From: ben smith 
Sent: 19 July 2011 09:55
To: Susan Leeson
Subject: FP/109/11 21 UPPARK WAY
Attachments: 03.pdf

Further to our recent discussion, I attach revised drawing 03. Assuming it is not too late, we would like you to determine the application on the basis of this substitute drawing. We note the following:

PROPOSED SITE AND ROOF PLAN

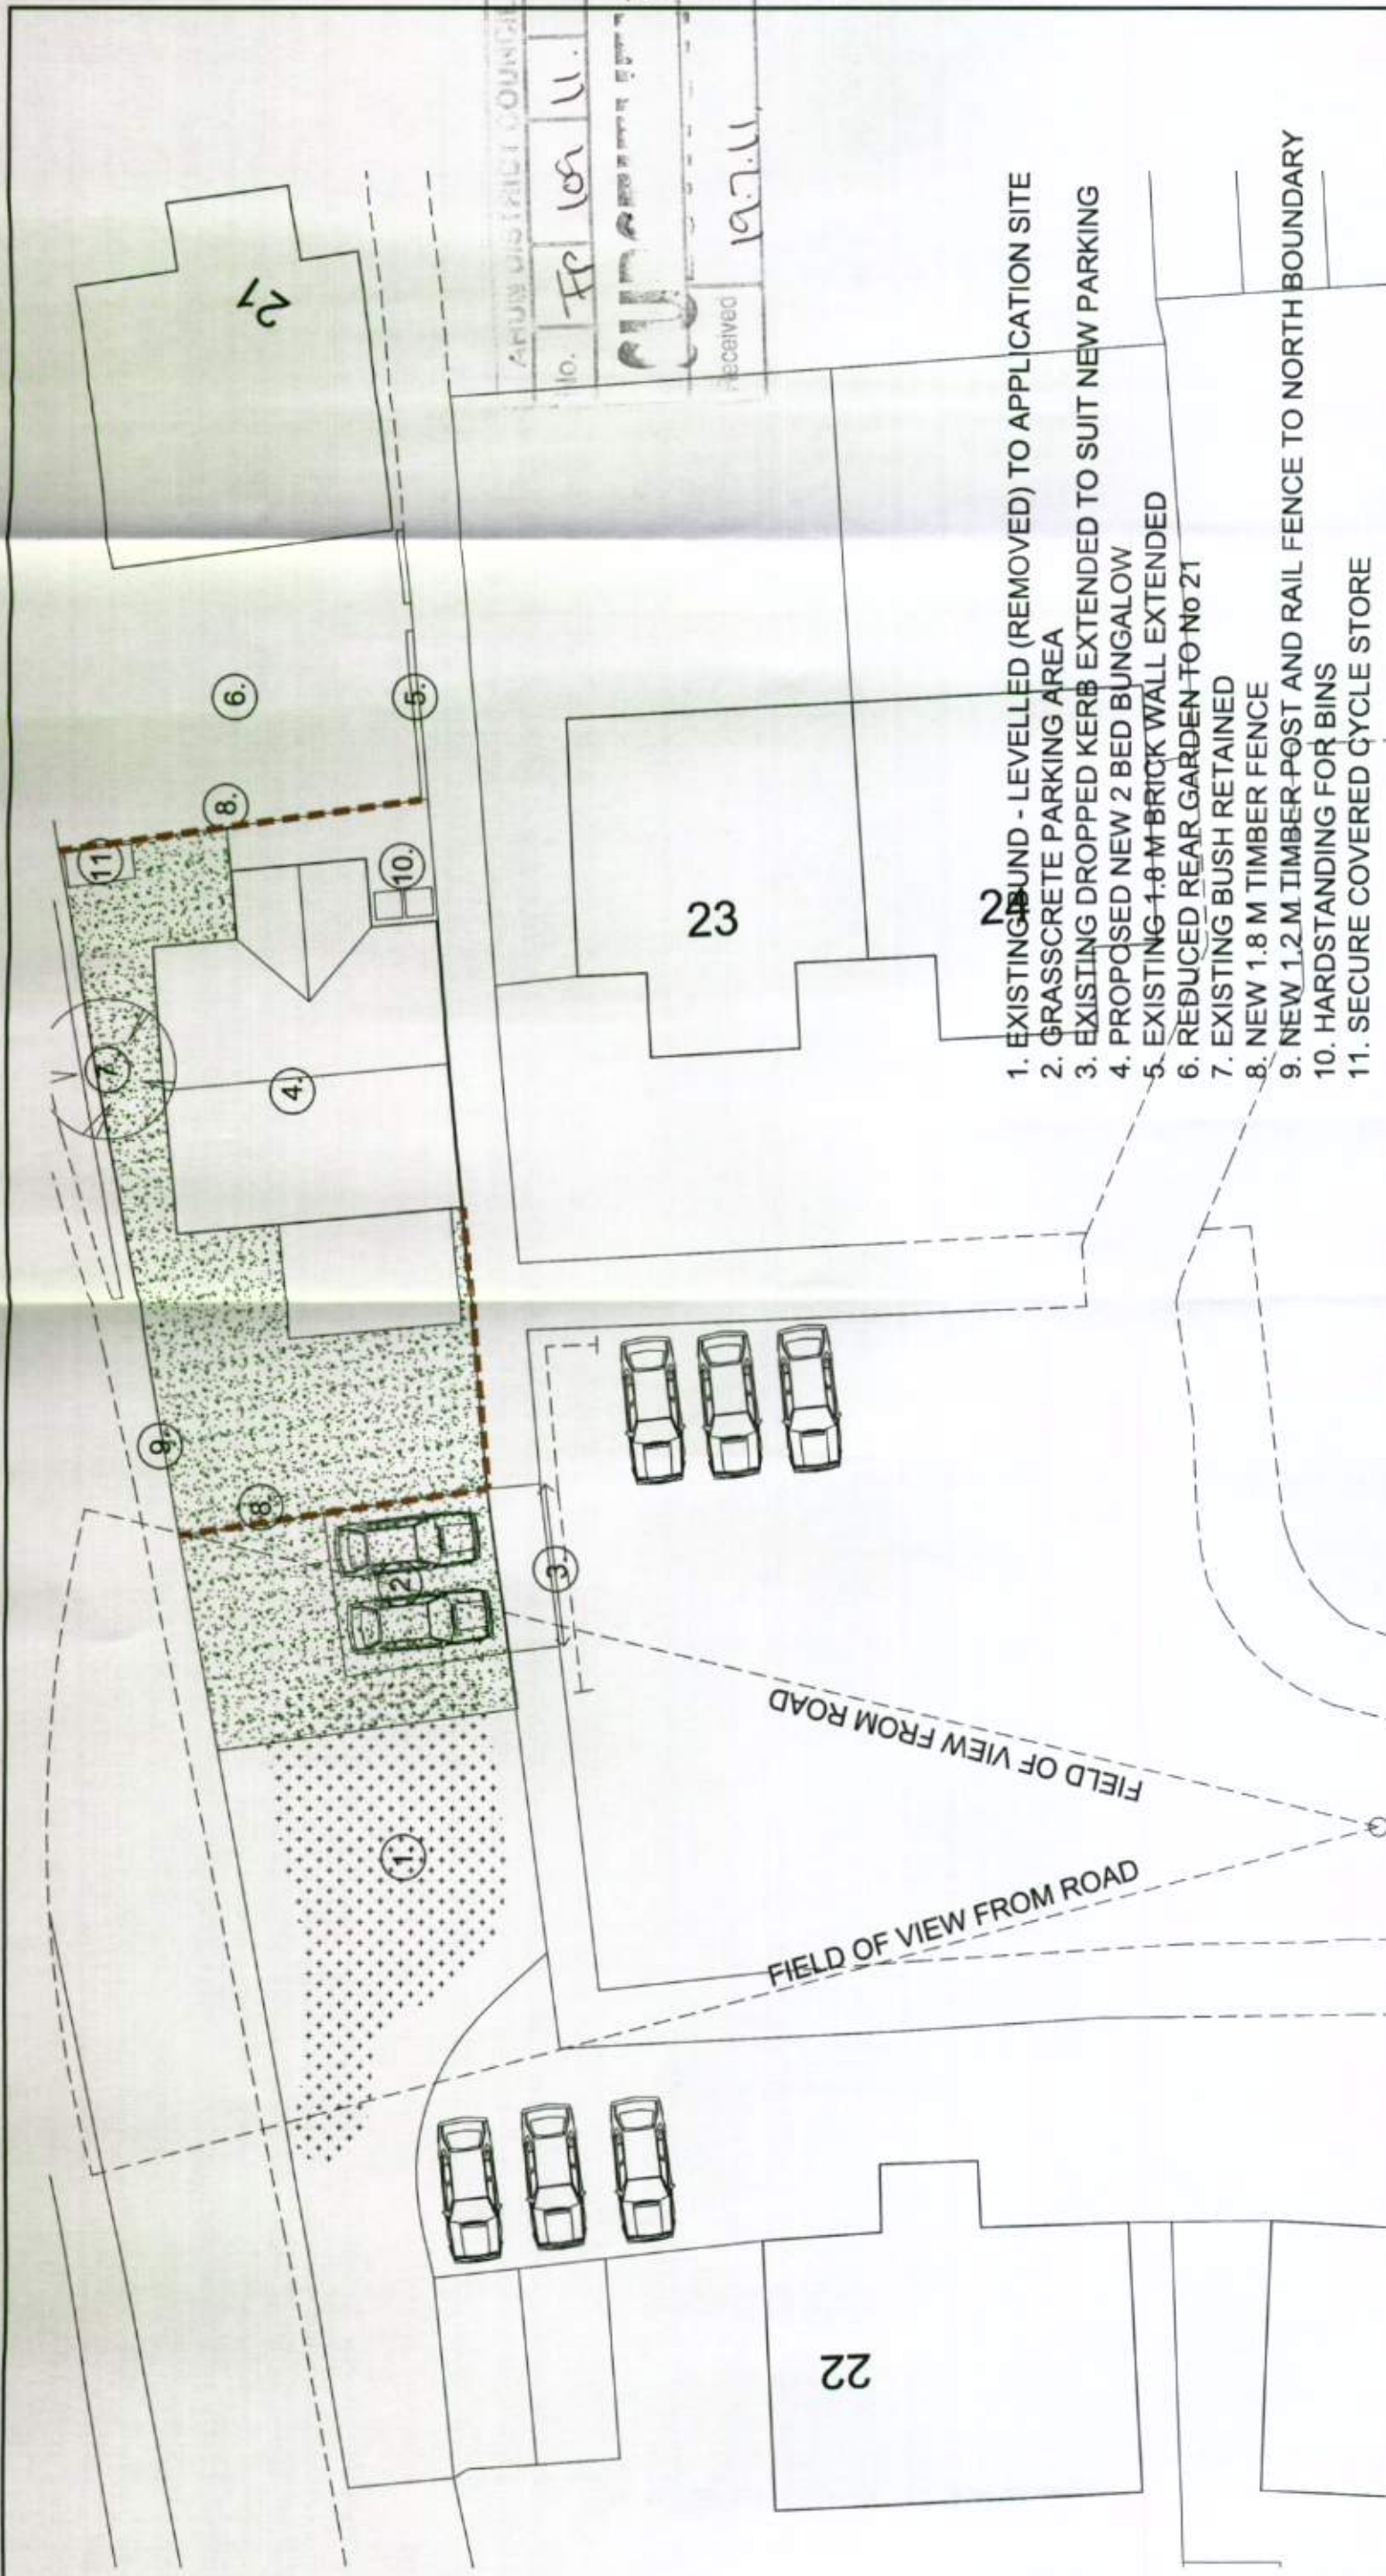
- Bins and secure cycle store moved to the east to de-clutter the view from the road.
- Bund to be removed from the application site and levelled – which further opens up the aspect from the road. We note that the owner of the other half of the bund is also open to the idea of removing his side of it.
- Parking moved slightly to the east and a more sympathetic finish proposed (grasscrete).
- Field of view from the road made clearer, demonstrating that the open aspect to the end of the road will remain.
